London Luton Airport Expansion

Buckinghamshire Council Comments on Further Deadline 3 Submissions

PINS REFERENCE: TR020001

November 2023

Figure C1: London Luton Airport noise monitoring stations and radar tracks, 2019

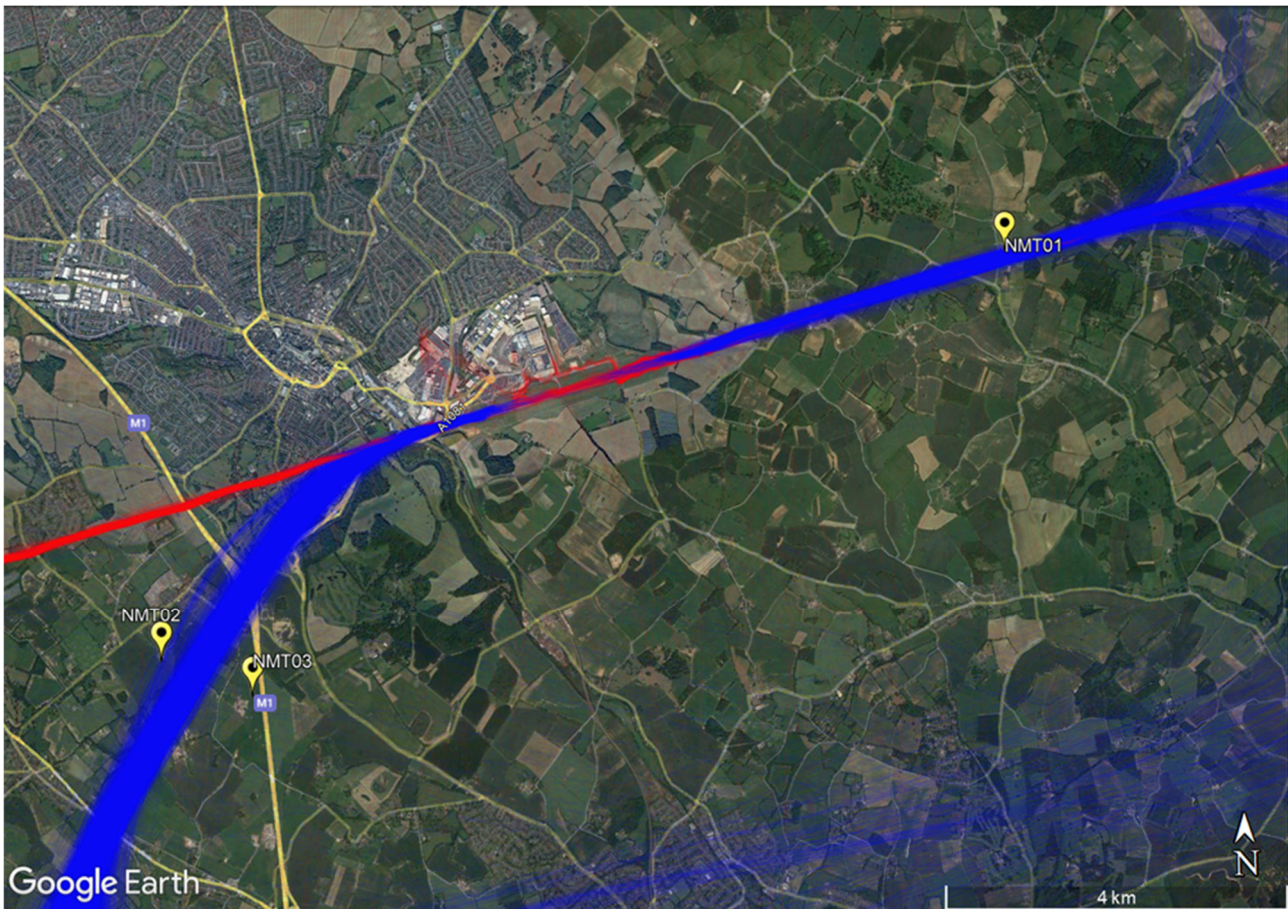
- 2.16.5. Paragraph C4.2.3: The Council asks for a permanent noise monitor in the Ivinghoe area. This is justified on the grounds that it would provide good data for monitoring the edge of the Applicant’s LOAEL contours where they are close to Buckinghamshire.
